# CITY OF ALBUQUERQUE

February 23, 2015

**Re: Smiles for Kids Dental Office  
Conceptual DMP and Conceptual Grading Plan  
Engineer's Stamp Date -no stamp- (C12D054)**

sheet title
Conceptual Drainage Management Plan

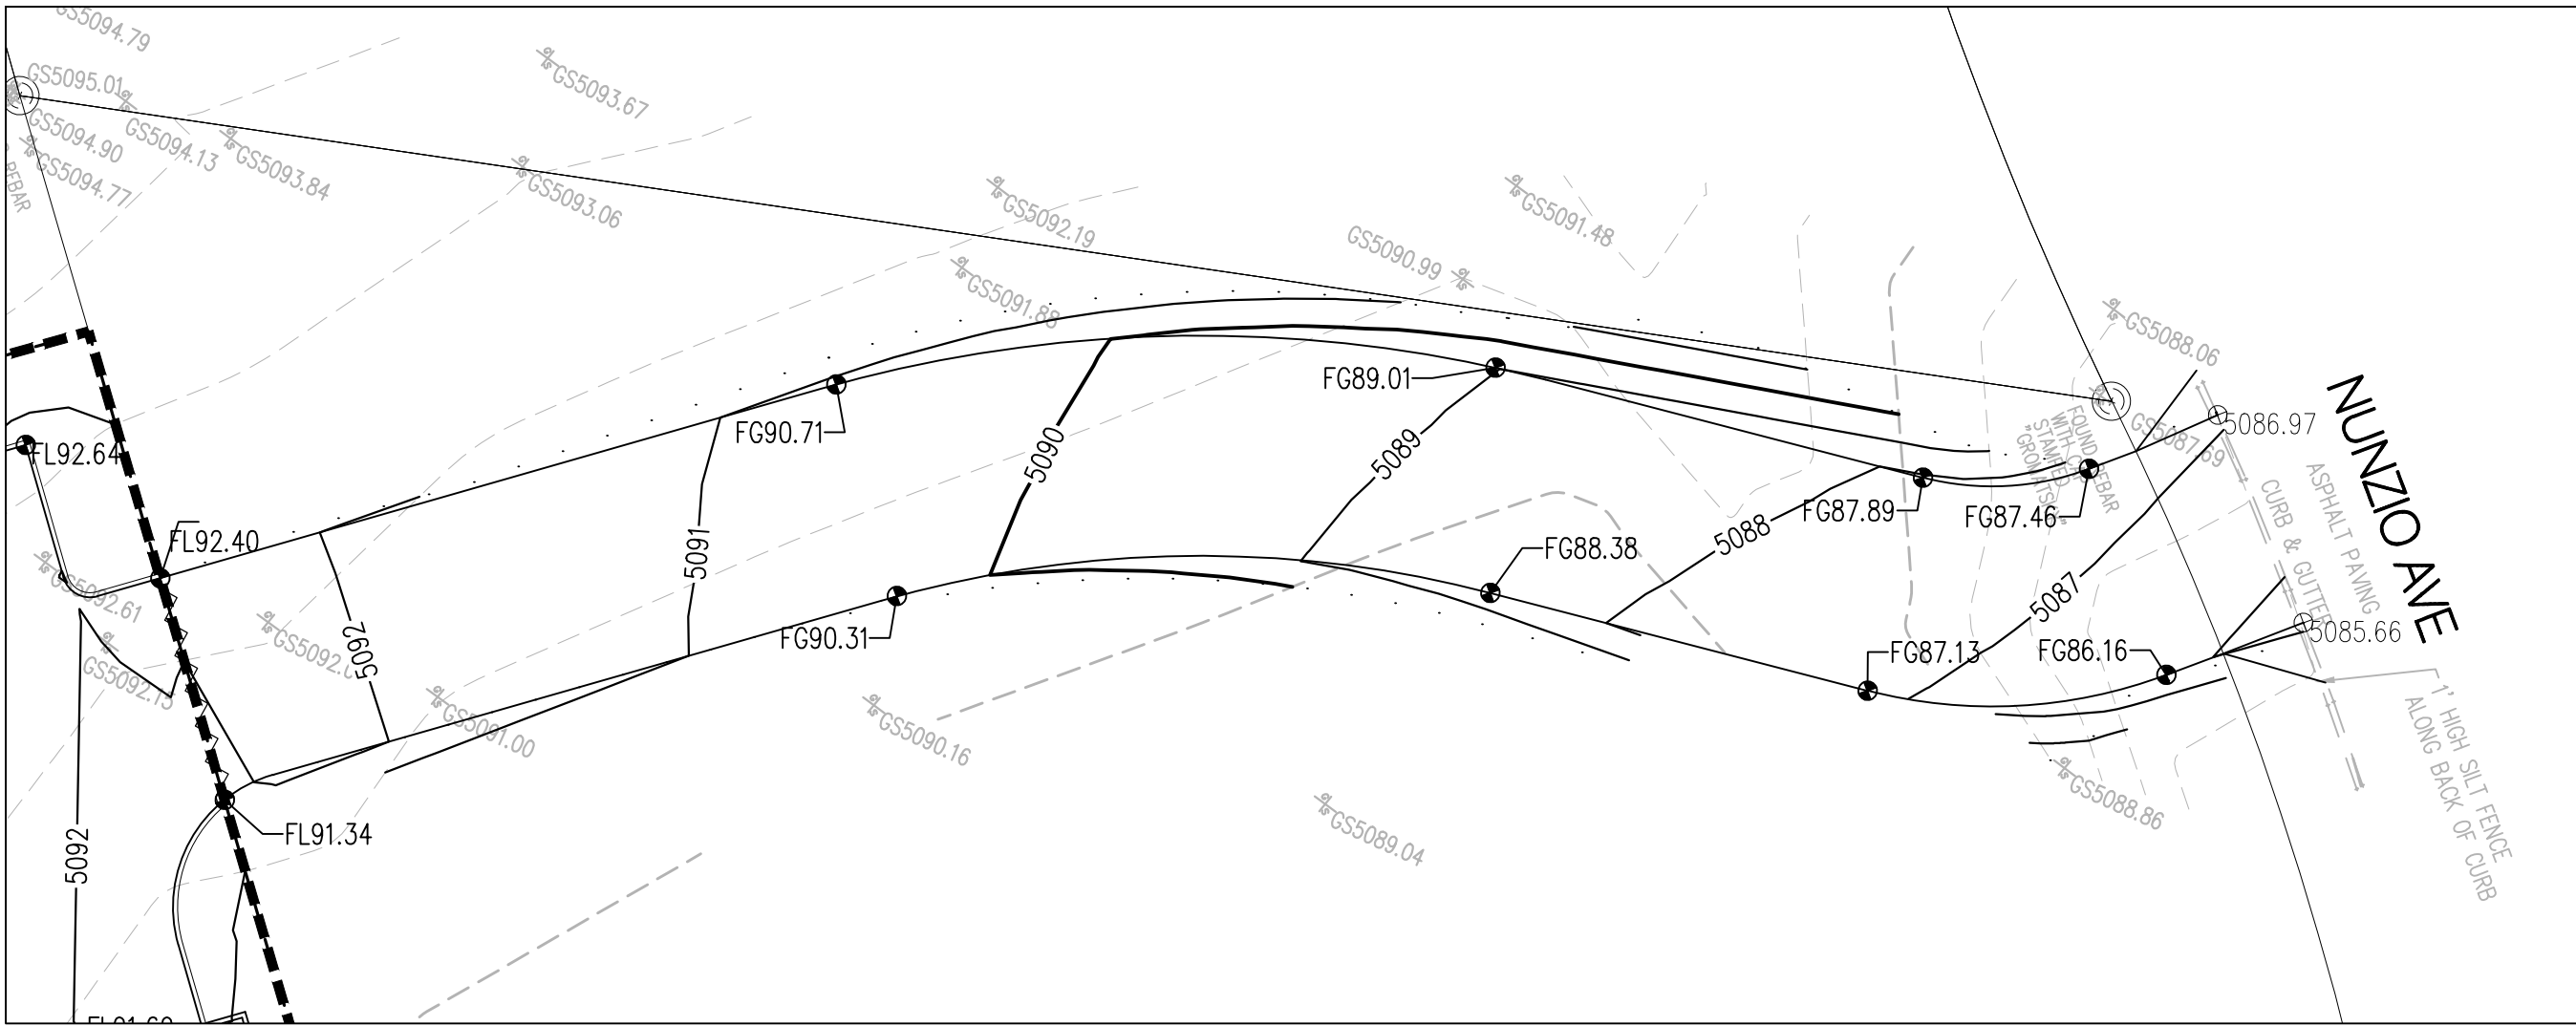
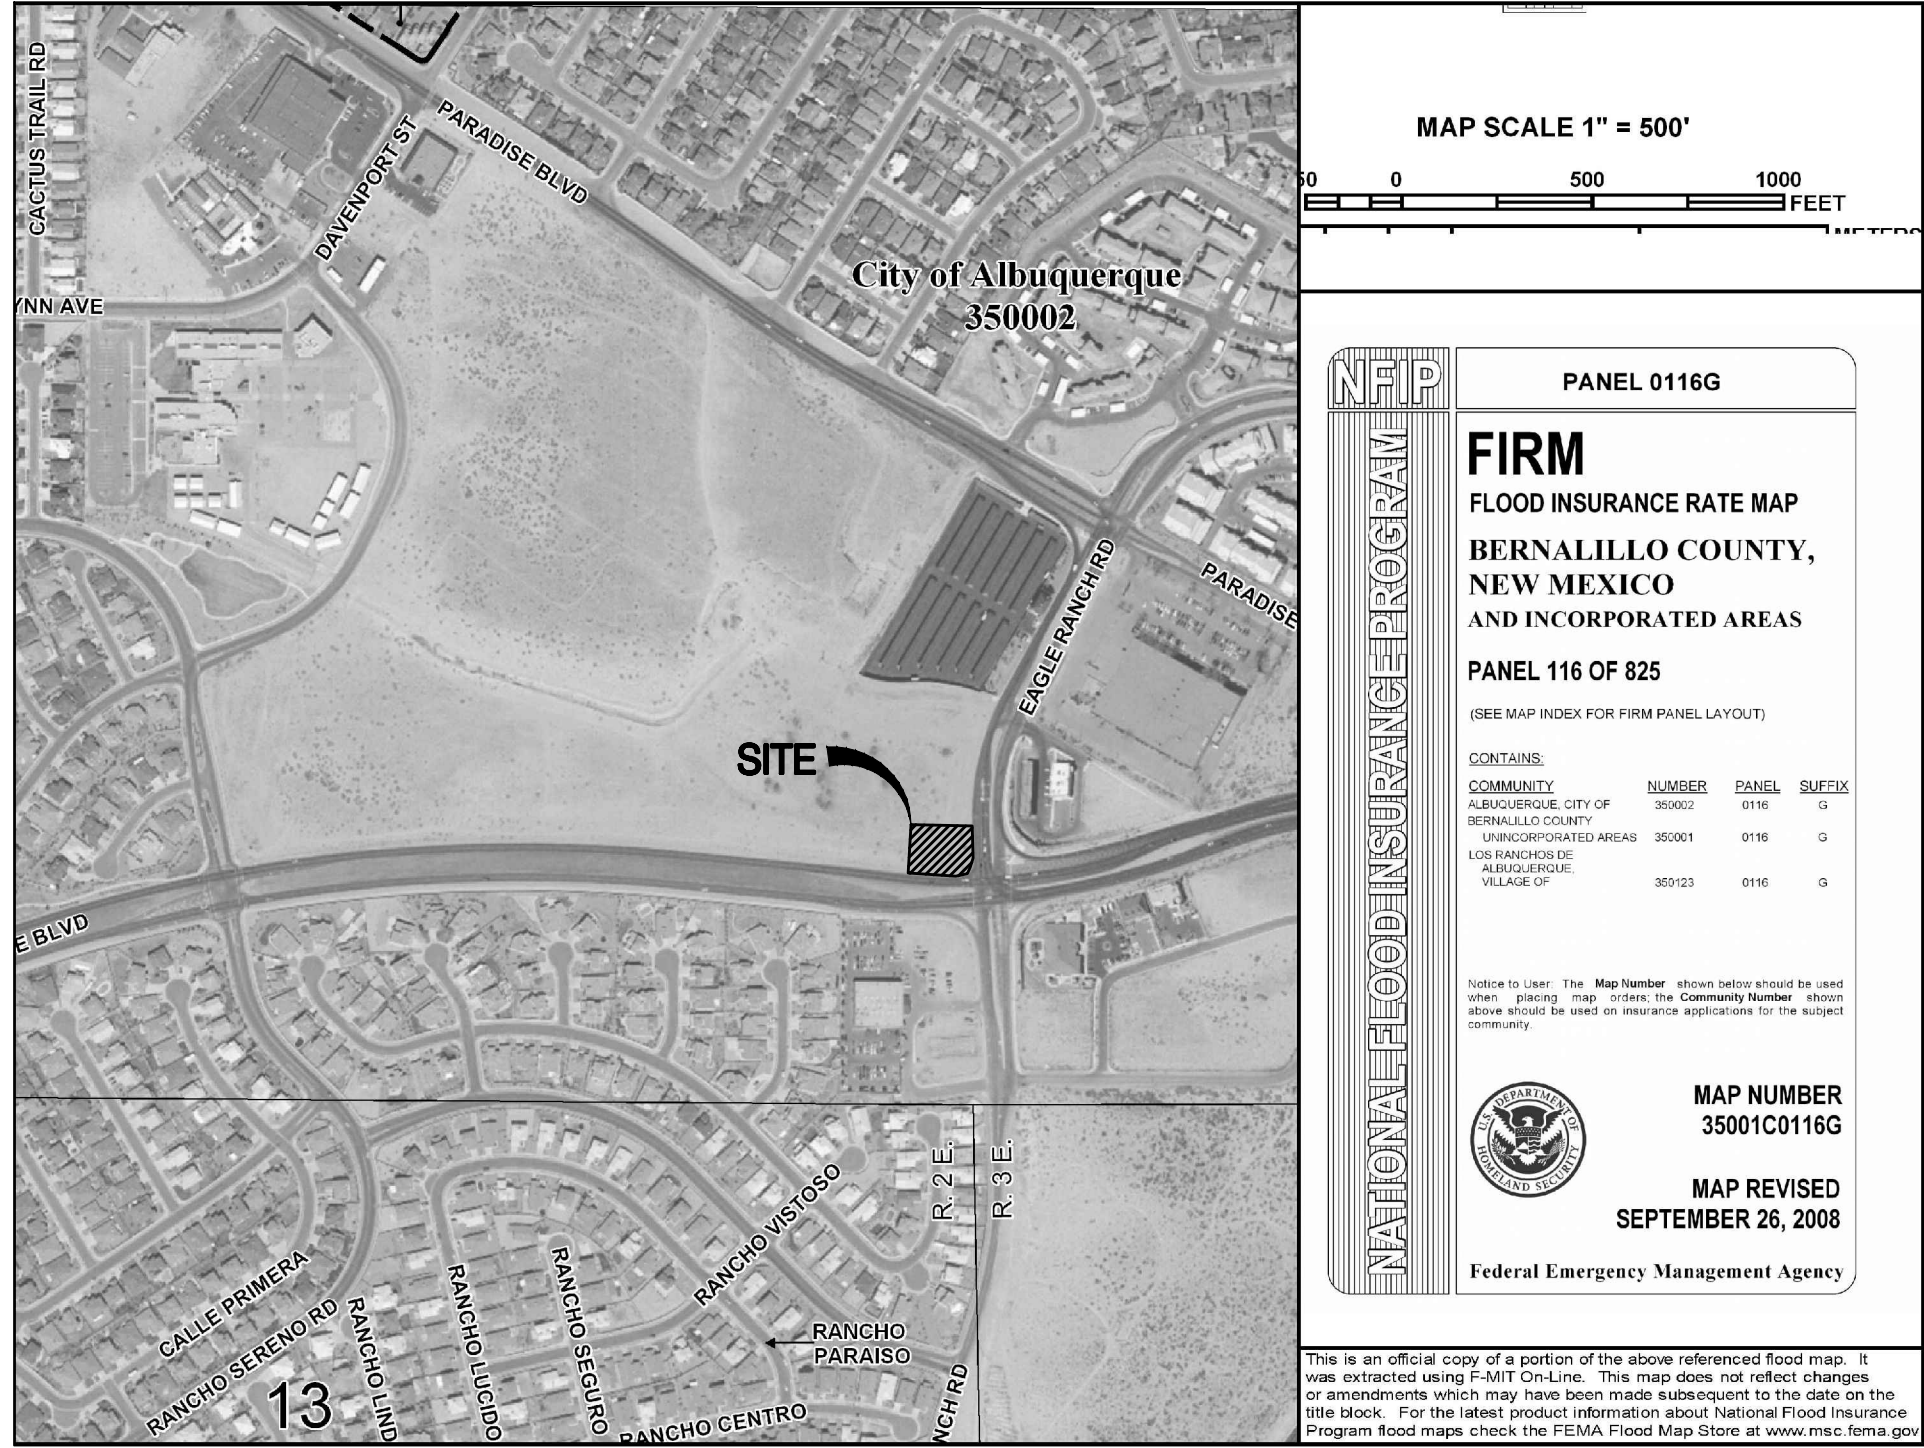
Based upon the information provided in your submittal received 2-17-15, the above referenced plans are approved for Site Plan for Building Permit action by the DRB with the condition that as access easement can be obtained across lot 10A1, which should be shown.

1. Provide the direction of roof flows.
2. Provide calculations for the channel and the sidewalk culvert.
3. Demonstrate, with a detail if necessary, how runoff from the landscape area on the east part of the site will enter the channel.
4. Explain why one building is hatched and the other is not.
5. Provided build notes for the curb cuts in the parking island that will receive the first flush.
6. Show curb, permanent or temporary, to be built on the access drive to Loma Fuente, at least on the downhill side.
